Ann Machado - 81 Brighton Ave. - Permit #2013-02572

From: Ann Machado
To: phillip.j.davis71@gmail.com
Date: 12/9/2013 8:12 AM
Subject: 81 Brighton Ave. - Permit #2013-02572

DRAWINGS THIS SHEET	
EXISTING CONDITION PLAN	A1
DEMOLITION PLAN	
PROPOSED FIRST FLOOR PLAN	
FOUNDATION / FRAMING PLAN	
ROOF FRAMING PLAN	
08/26/13

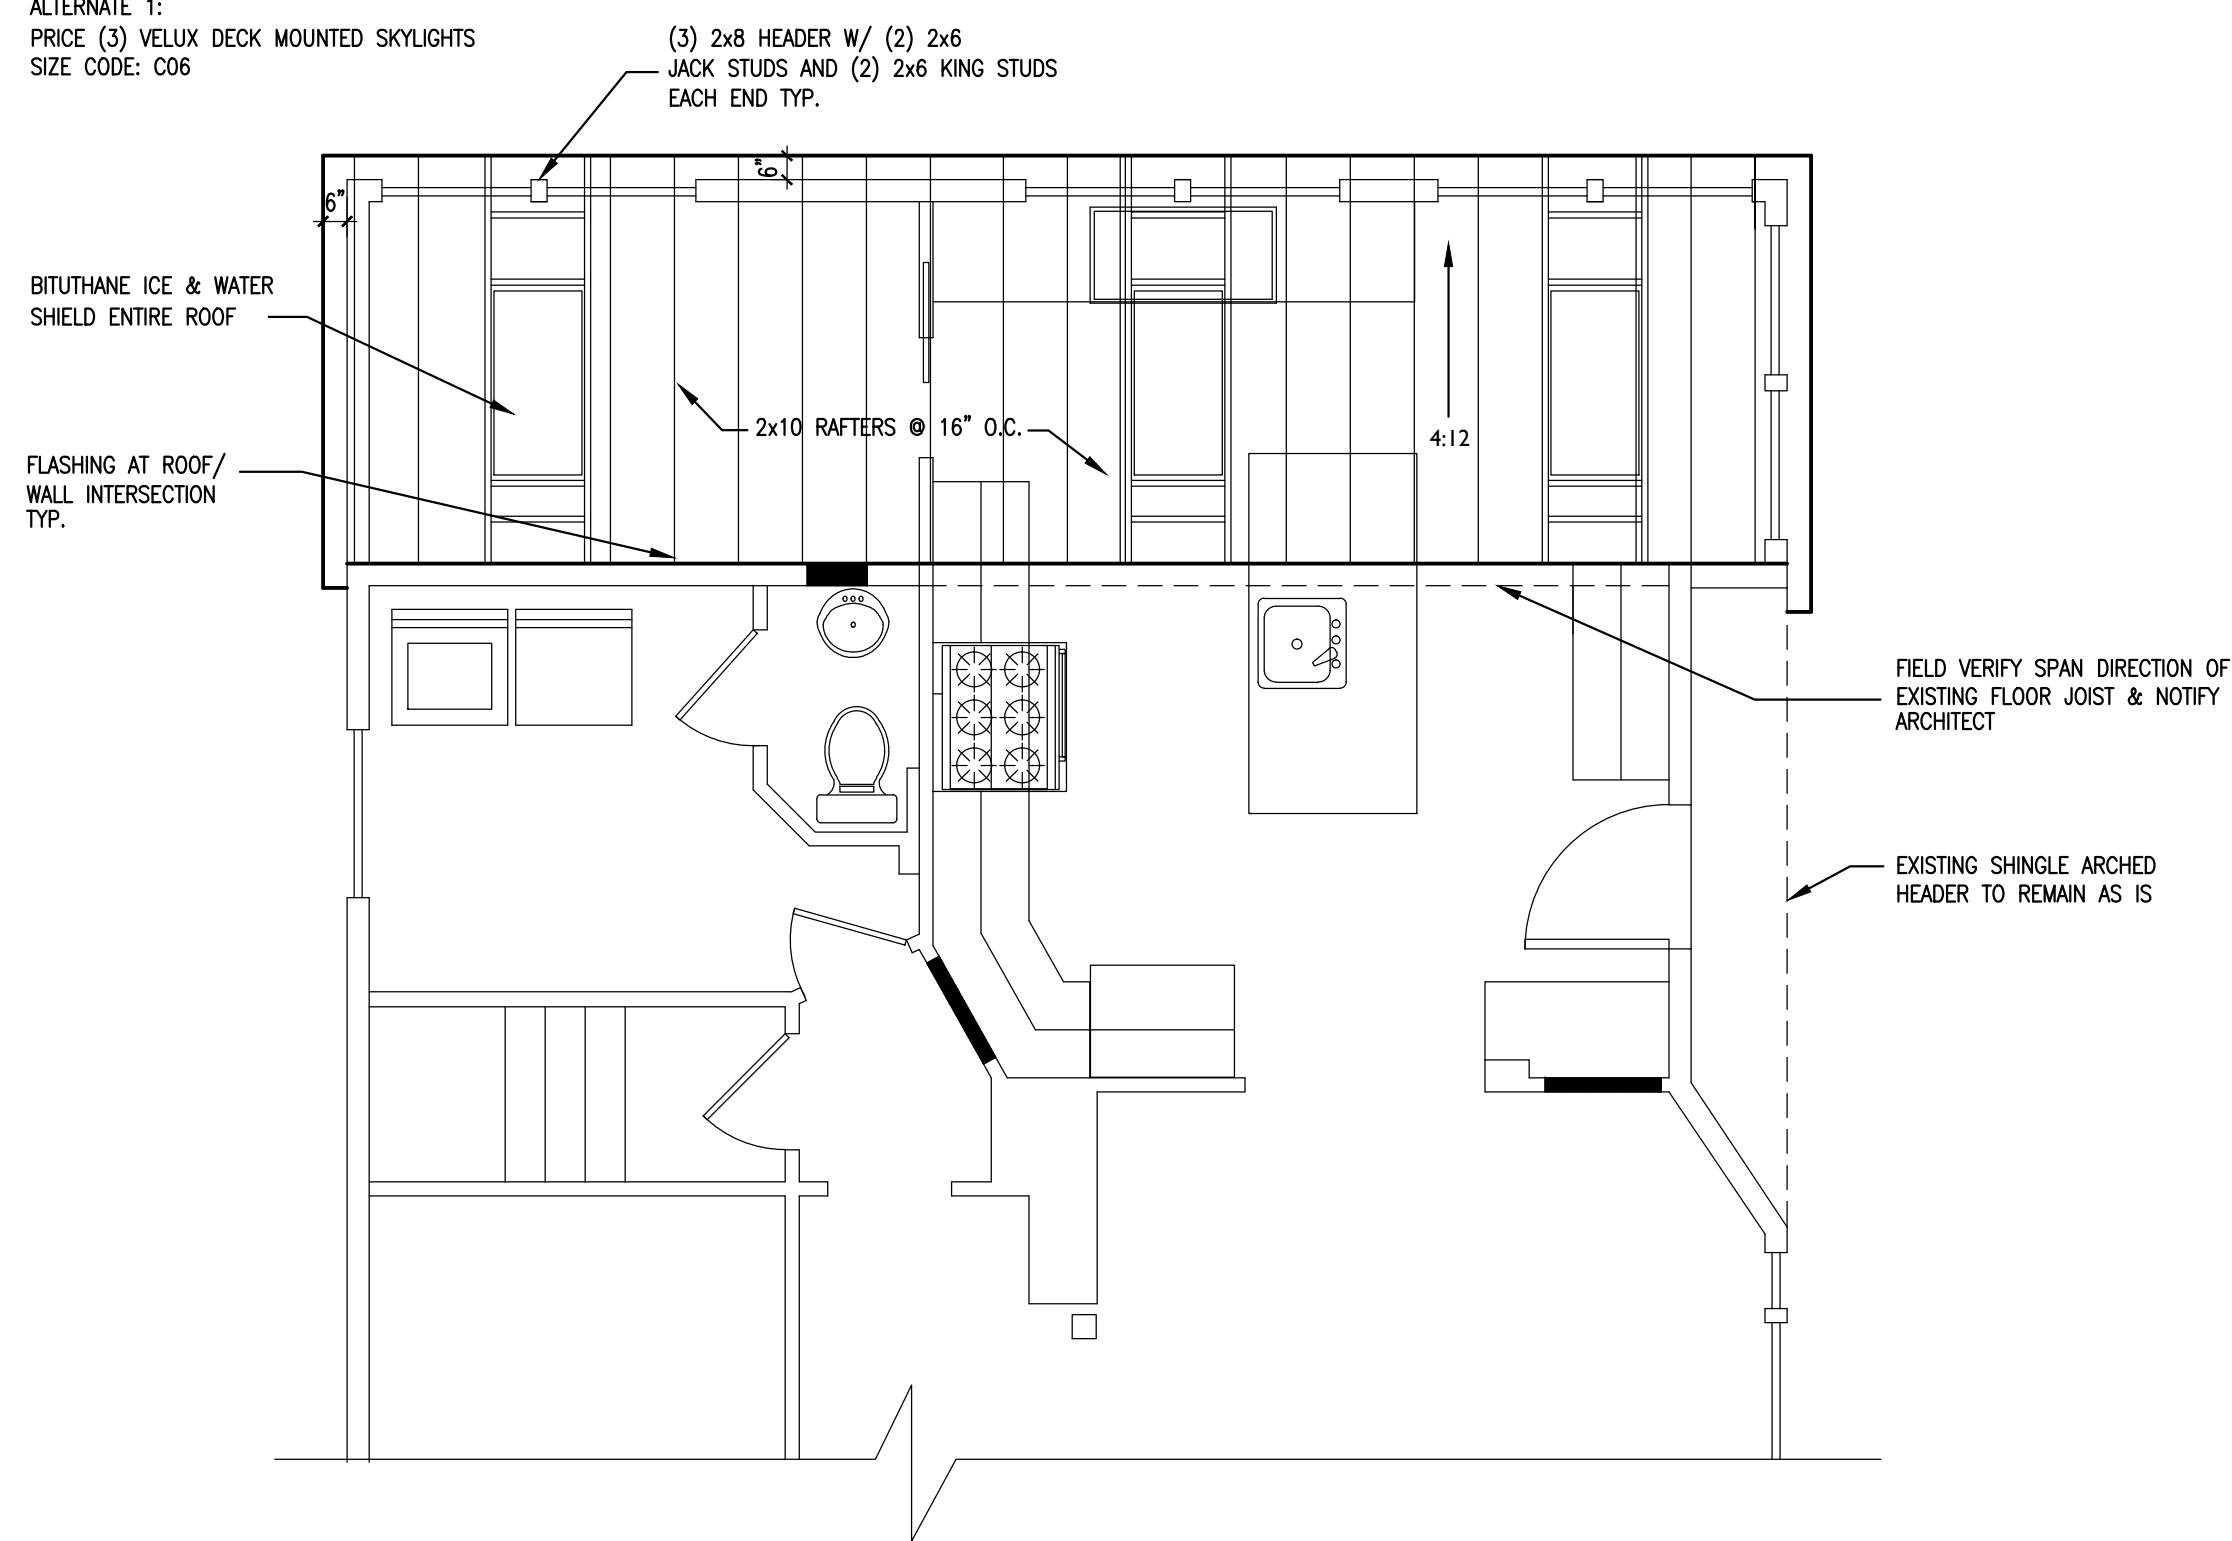
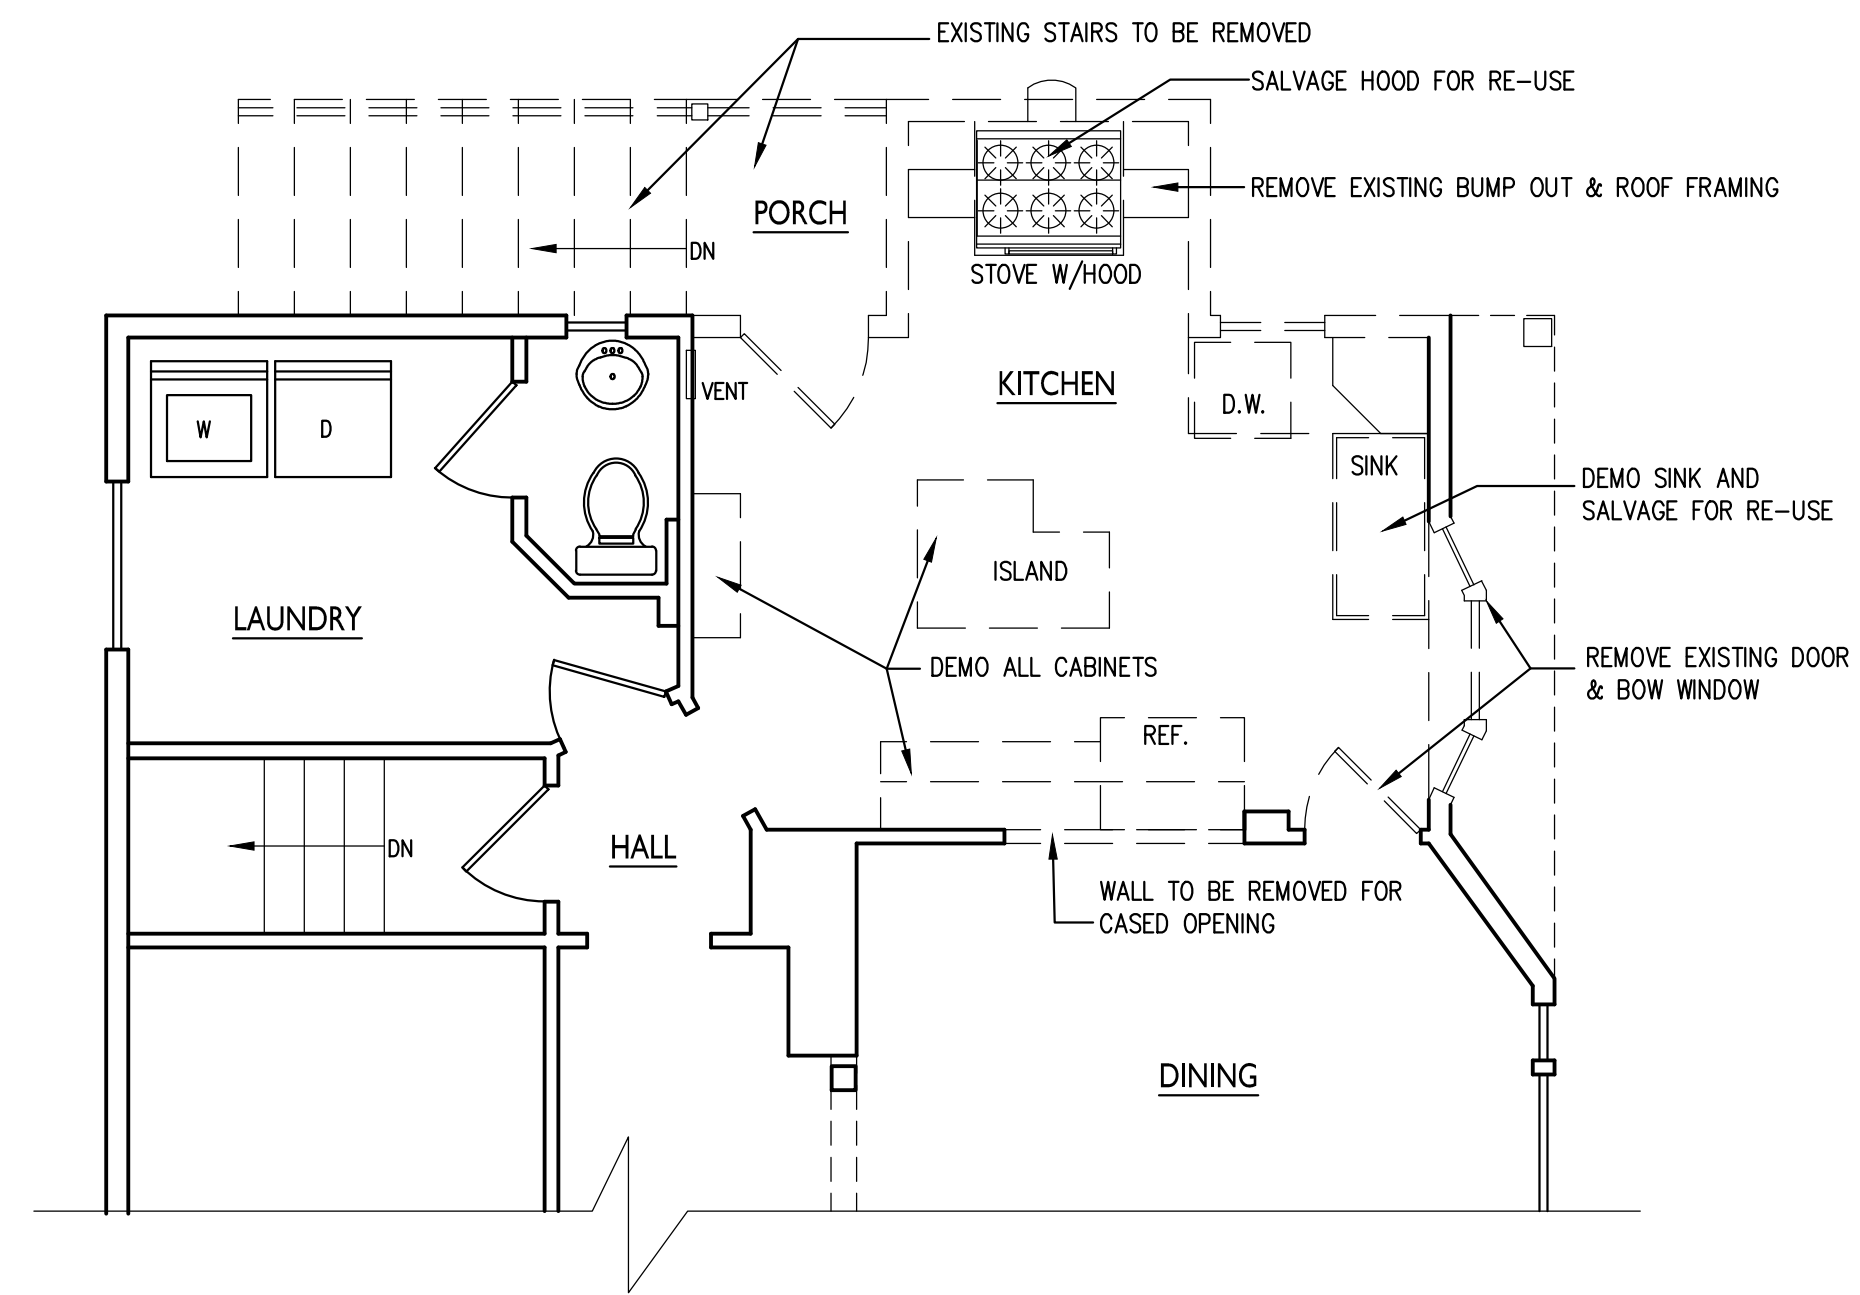
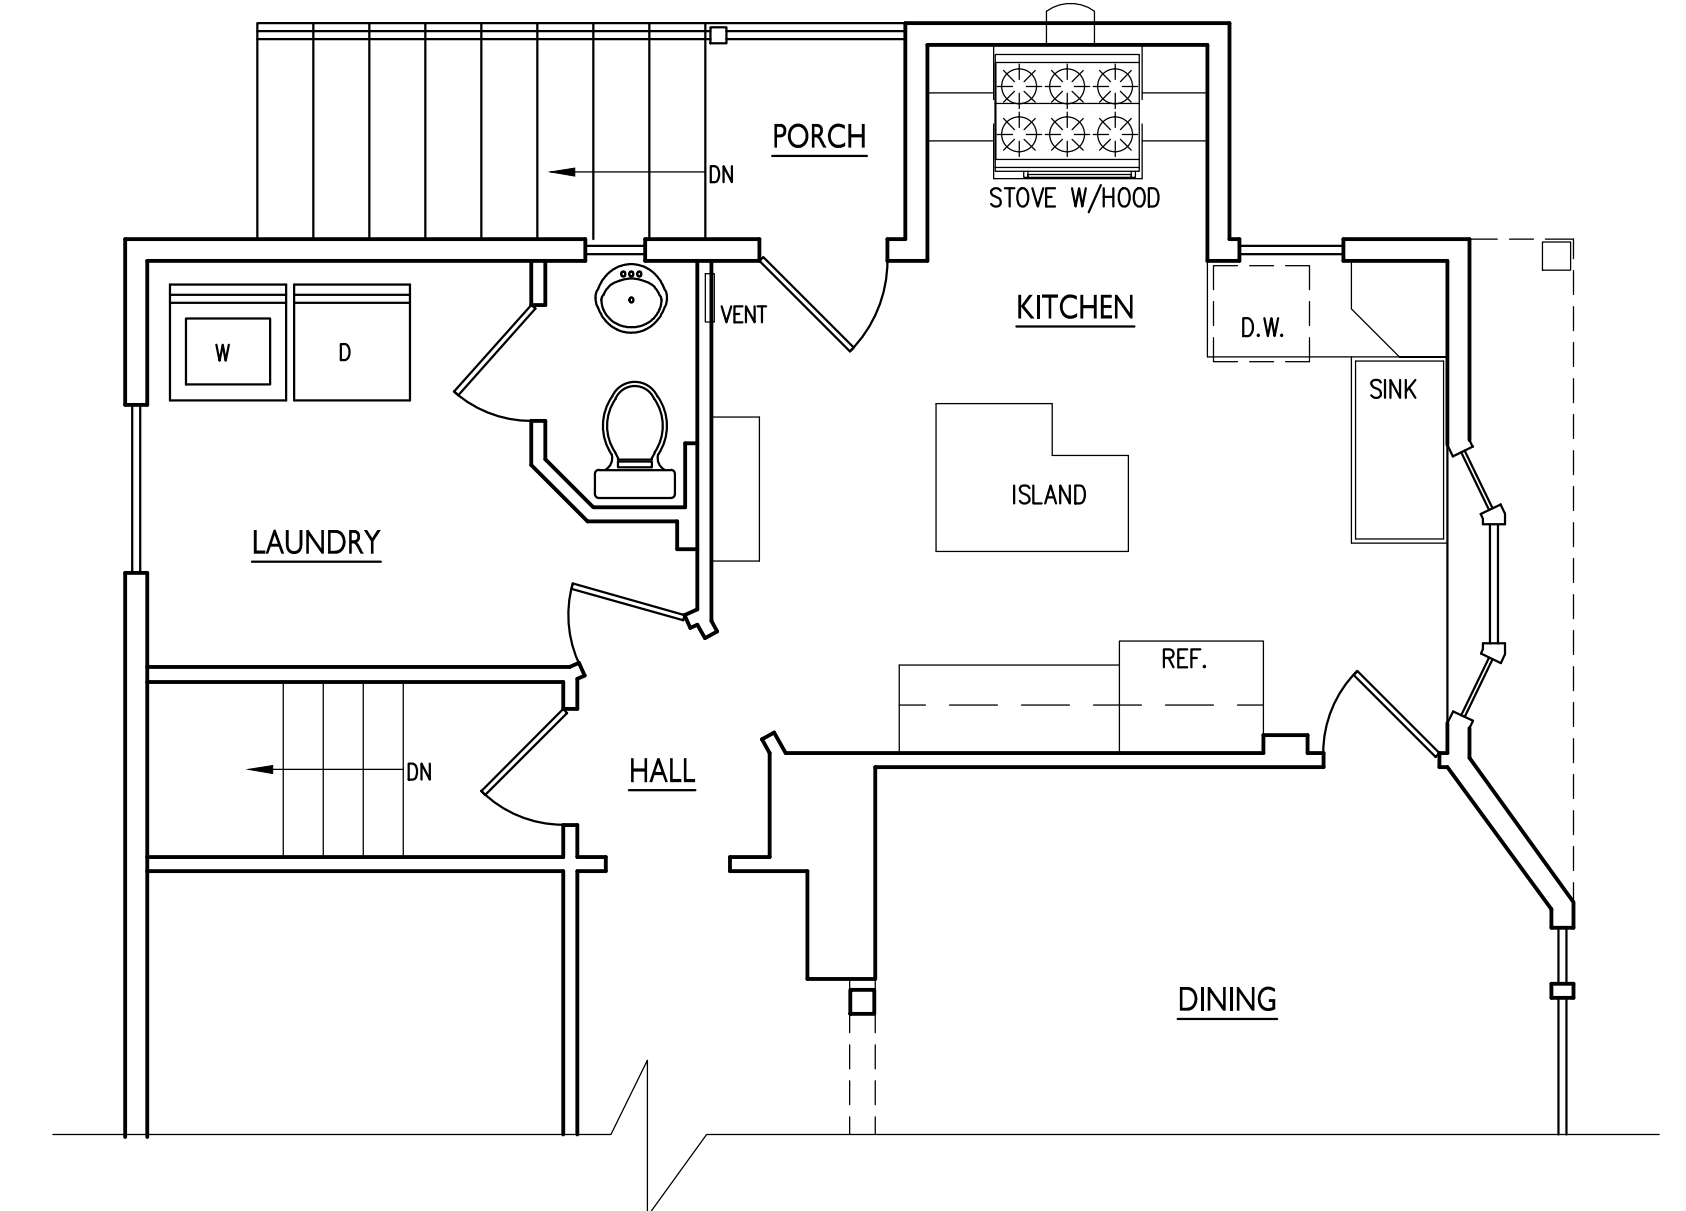
Also, now that we are doing electronic plan review, each plan needs to include a graphic or bar scale. We have to be able to calibrate our measuring tool when doing our review.
